Rezoning Transportation Analysis

Petition Number: 2020-068

General Location Identifier: Tax ID. 17514688

Date	Description
05-18-2020	First Review

SCHEMATIC SITE PLAN
PETITION # 2020-068
FOR
HEDGEMORE - MONTFORD PARK
CHARLOTTE, NORTH CAROLINA 28209

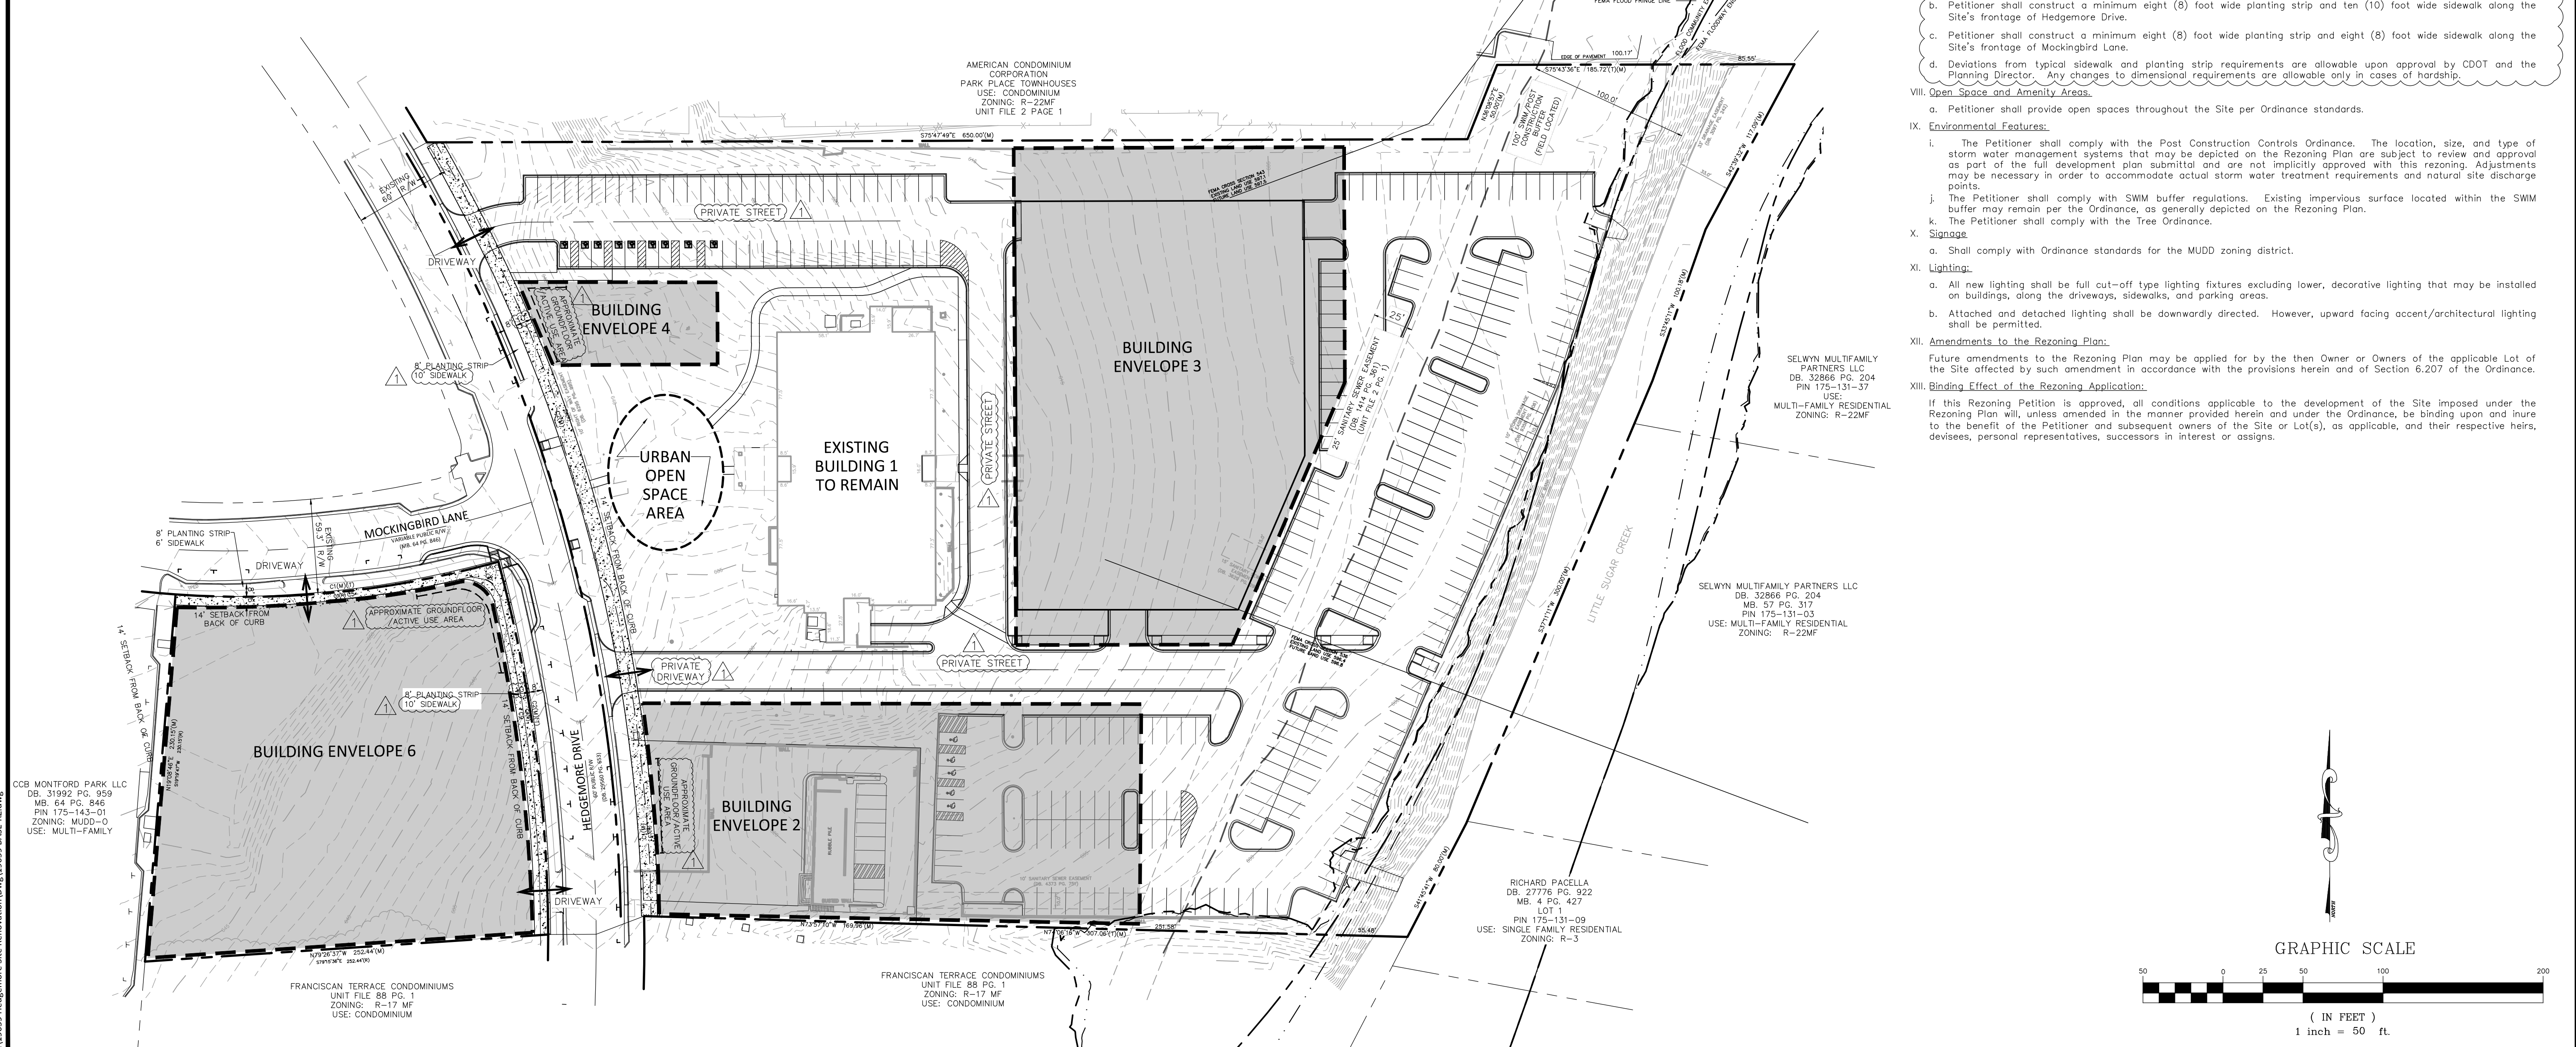
The site plan should show the curb and gutter labeled and dimensioned from the centerline for each road.

- The petitioner should revise the site plan and conditional note(s) to commit to constructing an 8-foot planting strip, and a 10-foot sidewalk on Hedgemore Drive per the Park Woodlawn Area Plan. The site plan should label and dimension both items from the back of curb and gutter to the road centerline.

- The petitioner should revise the site plan and conditional note(s) to commit to constructing an 8-foot planting strip, and an 8-foot sidewalk on Mockingbird Lane per the Park Woodlawn Area Plan. The site plan should label and dimension both items from the back of curb and gutter to the road centerline.

- The petitioner should revise the site plan to add a note specifying dedication and fee simple conveyance of all rights of way to the City before the site's first building certificate of occupancy is issued. CDOT requests right of way set at 2' behind back of sidewalk where feasible.
- The petitioner should revise the site plan to add a note specifying all transportation improvements will be approved and constructed before the site's first building certificate of occupancy is issued. The petitioner may phase transportation improvements if said improvements and phasing are explicitly described in site plan notes.
- Resolved** - Sample format for comment that is resolved
